Item No.	Report of the Head of Planning and Enforcement	
Address	2 LINKSWAY NORTHWOOD	
Development:	Part two storey, part first floor side extension, single storey rear extension, conversion of double garage to habitable use, installation of canopy to front and raising of roof to allow conversion of roof space to habitable use to include 3 rear dormers, 1 front dormer and 2 new gable end windows to front (Part Retrospective) (Resubmission)	
LBH Ref Nos:	36910/APP/2016/4594	
Drawing Nos:	A203 - As-Built Plans & Elevations - Rev B(1) A202 - Approved Plans & Elevations - Rev A A201 - Pre-Existing Plans & Elevations A102 - Proposed Block Plan A101 - Location Plan	
Date Plans Received:	21/12/2016	Date(s) of Amendment(s):
Date Application Valid:	21/12/2016

The current application seeks to regularise alterations in the design, scale and footprint of the extended dwelling in its 'as built' form, which differ from that which was approved under 36910/APP/2015/621.

AS BUILT FRONT ELEVATION (A)

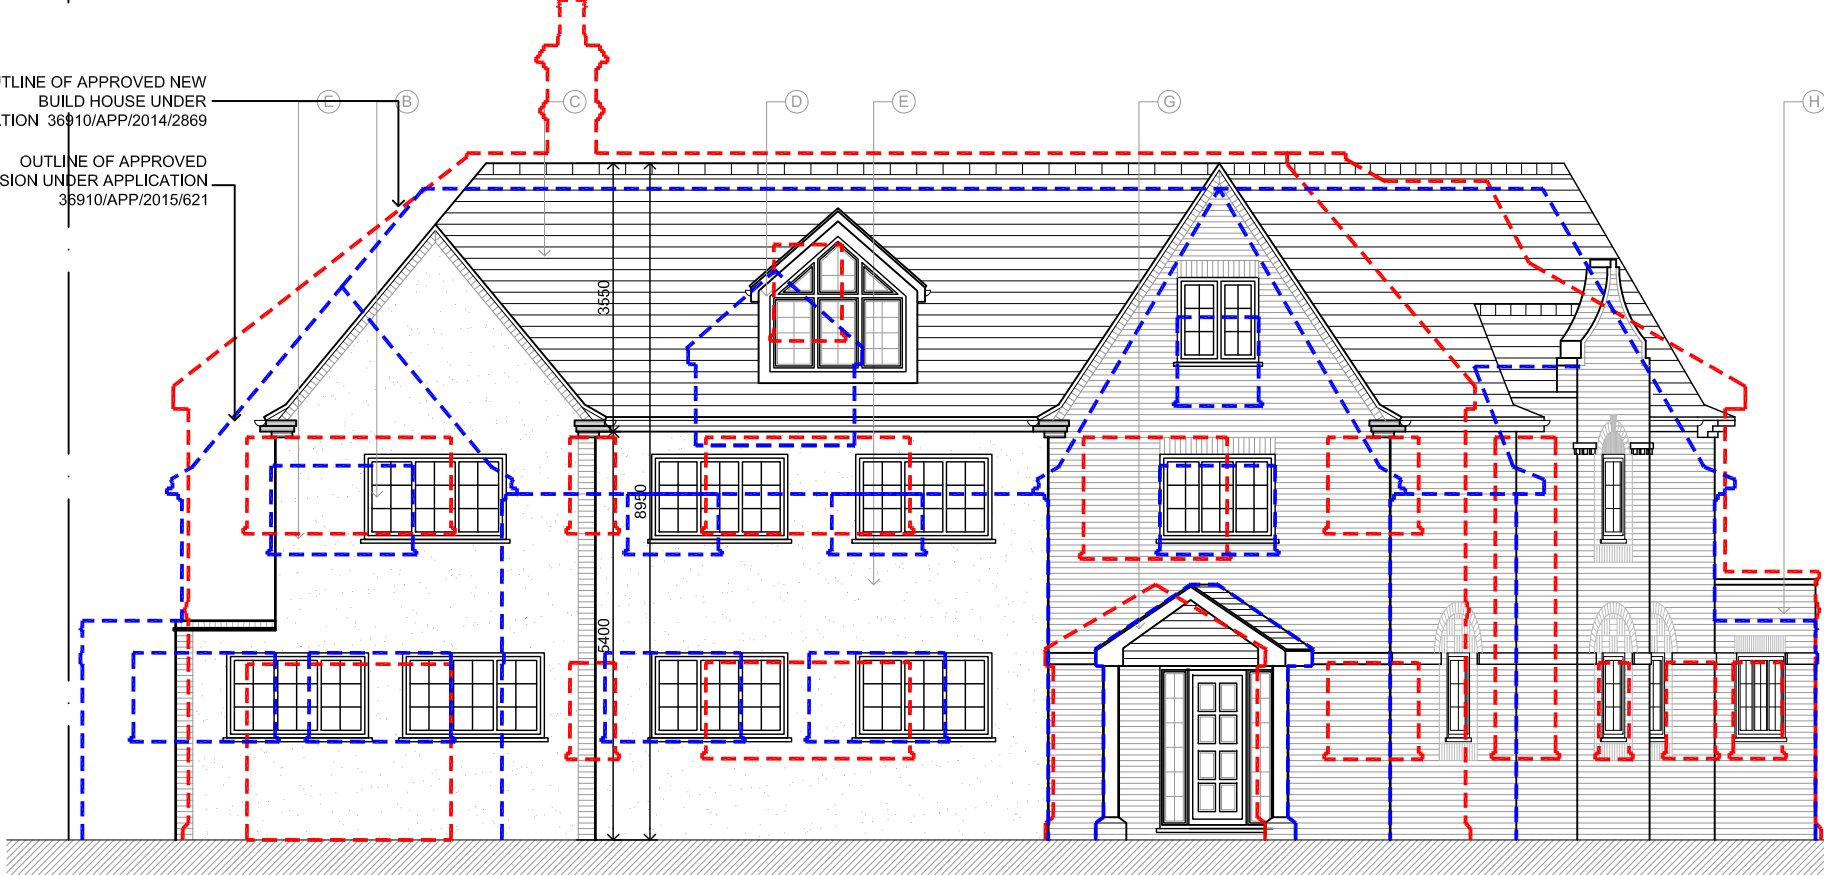
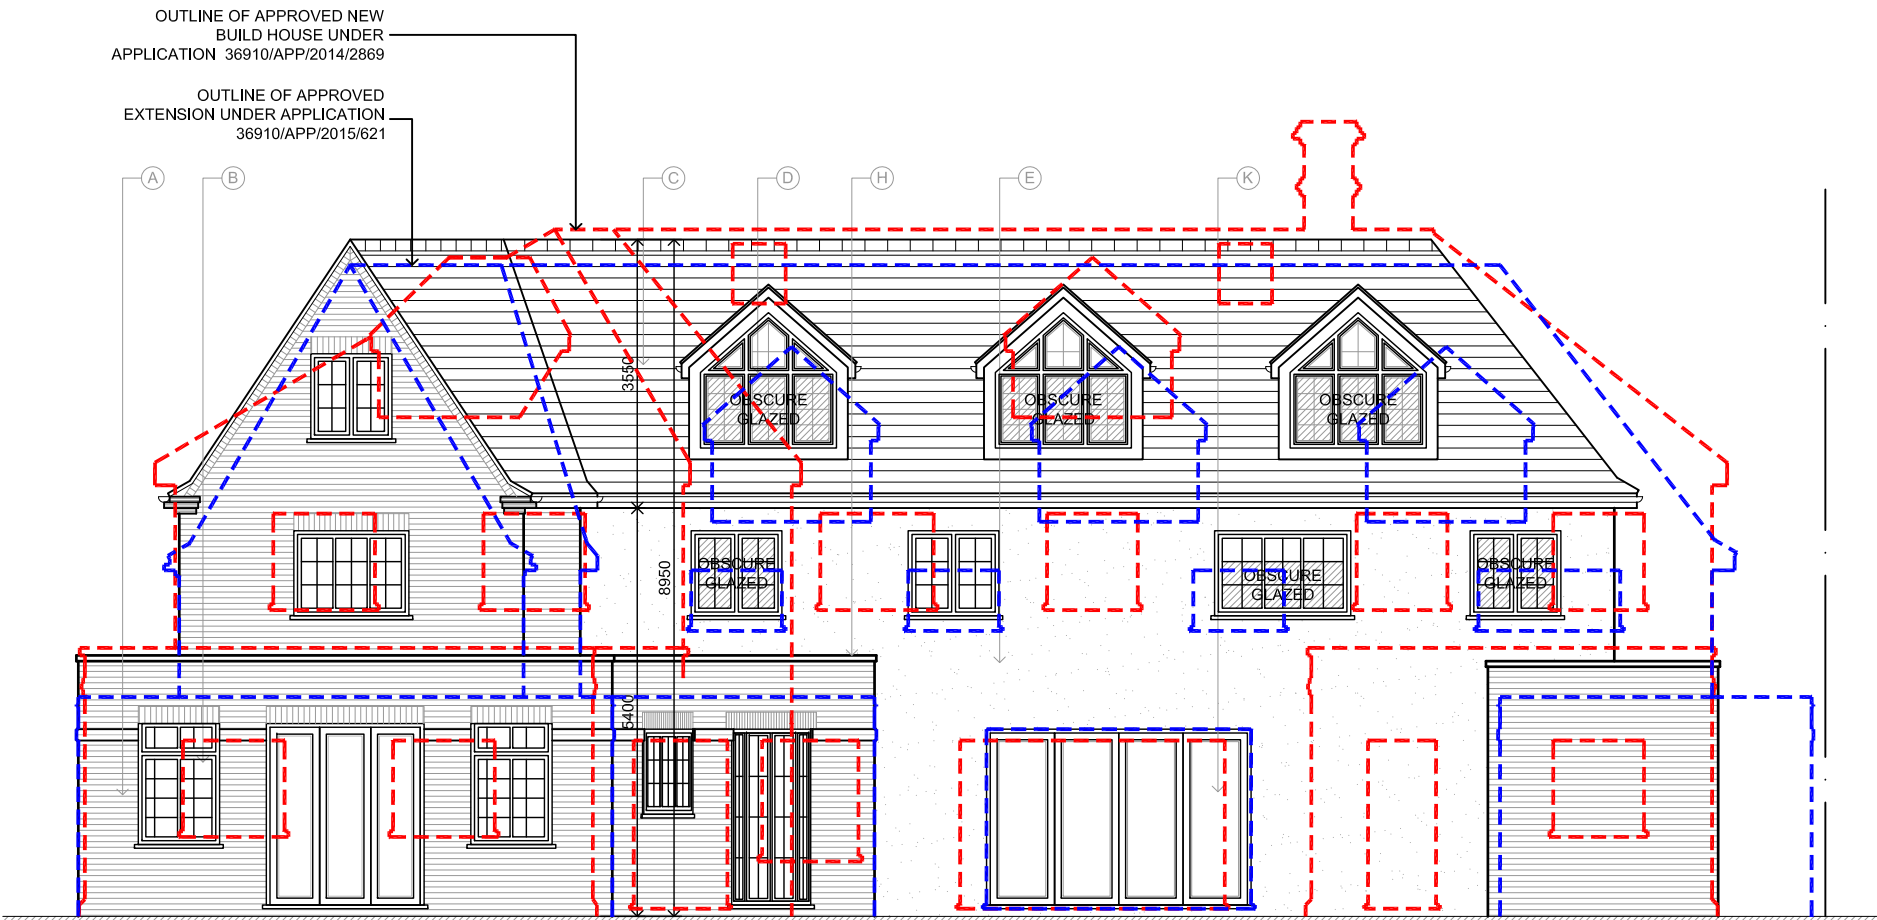
The 'as built' structure exceeds the height permitted by the approved application with the ridge height being increased by 0.335 metres and the eaves height being more substantially increased by 0.8 metres. By raising the eaves, the 'as built' dwelling has vertical walls of an increased height which appear significantly more prominent than in the approved permission. As a result, the building elevations appear more stark and visually prominent and it is considered that this is unacceptable given the visual sensitivity of the site and its surrounds and due to the fact that the previously approved development was

considered to be at the maximum scale appropriate for the plot. Furthermore, the approved application had the eaves directly above first floor windows, which is a common characteristic of buildings on Linksway including the host dwelling, the increased eaves height has left a gap between the top of first floor windows and the eaves which is not consistent with this distinguishing feature within the surrounding area. It is therefore considered that the development does not satisfy the requirements of Local Plan policies BE 5, BE 6, BE 13 and OE 1 and policies 7.4 and 7.6 of the London Plan.

The increase in the height of the eaves is not matched by an increase in ridge height and this has resulted in a roof form that is shallower than that which was approved. As a result, the proportions of the building have been altered which, again, has resulted in a more prominent and overly dominant structure. The decrease in roof size has also resulted in the prominence of the various dormer windows being exaggerated to a degree that they are less sympathetic towards the form of the building as a whole.

The unacceptable scale and massing of the development now built is further emphasised by the disproportionate increase in the height of the single storey additions to the side and rear. These have increased by 0.5 metres and now extend close to the cill level of the enlarged first floor windows. The result of such, is that the proportions of the building appear visually at odds with the scale and form of the host building and dominate the ground floor to an unacceptable degree. These also make these additions more prominent in view from surrounding properties/street scene and result in the elevations appearing cramped and contrived in form.

considered that these windows would compromise the privacy of neighbouring residents due to the orientation of the windows relative to those within No. 3 Copse Wood Way. Further, a number of the windows at first and second floor served en-suite bathrooms and were therefore to be obscurely glazed. The reconfiguration of the internal layout of the building has resulted in habitable rooms now being served by windows in a similar position to where obscure glazed windows serving bathrooms and storage space were originally approved. The previous application was refused, in part, due to the potential overlooking of the garden space at 3 Copse Way that would be offered by windows serving these re-positioned rooms. The applicant has sought to address this concern by applying an obscure film to the windows concerned and restricting the opening angle of the windows. It is considered that obscure glazing adequately addresses the overlooking concerns but that a more permanent means of obscure glazing should be used. A condition can be attached to any approval given to require obscure glazing to be permanently maintained. The current arrangements for restricting the opening of the windows is insufficiently robust and lacks permanence. In order to secure privacy the windows should be fixed shut with ventilation provided only by fanlight openings set a minimum of 1.8 metres above internal floor level. A condition could also be attached requiring this change to be made.

The second floor bedroom is served by a front facing window that does not require obscure glazing and it is therefore considered that adequate natural light and outlook would be available to this room. The window serving bedroom 2 (as referred on the accompanying plan A203 Rev C) at first floor level has not been obscurely glazed. However, this window was approved with clear glazing under 36910/APP/2015/621 and it does not offer overly intrusive views towards 3 Copse Way due to its orientation and modest size. The window serving bedroom 3 on the same floor has been partially obscure glazed as the outlook is towards a secondary bedroom window and the wider garden area. It is considered that this obscure glazing is therefore necessary in order to comply with Local Plan Policy BE 24 but that it presents a significant barrier to natural light penetration within the bedroom which is not served by any other windows and also present a poor outlook. It is therefore considered that the living conditions within the room are not of an acceptable level for it to be used as a bedroom. The development is therefore considered to conflict with Policy BE 20 of the Local Plan and para. 4.9 of the Residential Layouts SPD.

Overall, the alterations are considered to result in a development that would appear unduly dominant and overbearing when viewed from the neighbours garden at No. 3 Copse Wood Way and from the wider public domain. It is considered that the current application of obscure glazing does not fully address overlooking concerns given that the windows can still be opened, however, it is considered that this can be overcome by way of applying a planning condition if approval is granted. Furthermore, it is considered that the use of obscure glazing in bedroom 3 has resulted in unacceptable living conditions

The resultant scale and massing of the 'as built' extensions are considered to dominate the prominent corner setting to an unacceptable degree. The alterations would detract from, and fail to harmonise with, the character, form and modest scale of development within the surrounding street scene and Area of Special Local Character to the detriment of the building's appearance and setting. The scheme would thereby be contrary to Policies 7.4 and 7.6 of the London Plan, policy BE1 of the Hillingdon Local Plan: Part One - Strategic Policies, BE5, BE13 and BE19 of the Hillingdon Local Plan - Saved policies and HDAS 'Residential Extensions'.

The 'as built' alterations to the extension by reason of the proximity, siting, size of the windows and internal are considered to overlook the private garden of No. 3 Copse Wood Way to an unacceptable degree, to the detriment of these occupiers. The proposed obscure film applied to the overlooking windows and the ability for those windows to be opened are not considered to provide a sufficiently permanent or robust means of mitigating the overlooking of the neighbouring rear garden. The application would thereby erode the privacy and living conditions of these occupants to an unacceptable degree. Further, the increase in the height of the extensions would result in a scheme that would appear unduly dominant and visually overbearing to the detriment of the amenities of No. 3 Copse Wood Way. The application therefore fails to comply with the NPPF, Policies BE21 and BE24 of the Hillingdon Local Plan: Part Two - Saved Policies and HDAS 'Residential Extensions'.

The use of obscure glazing within Bedroom 3 (as identified in accompanying plan A203 Revision C) results in a habitable room in the extended property from receiving sufficient daylight and provides that room with an inadequate outlook, to the detriment of the living conditions of that property and the residential amenity of future occupiers. The application therefore fails to comply with Policy BE20 of the Hillingdon Local Plan - Saved Policies.
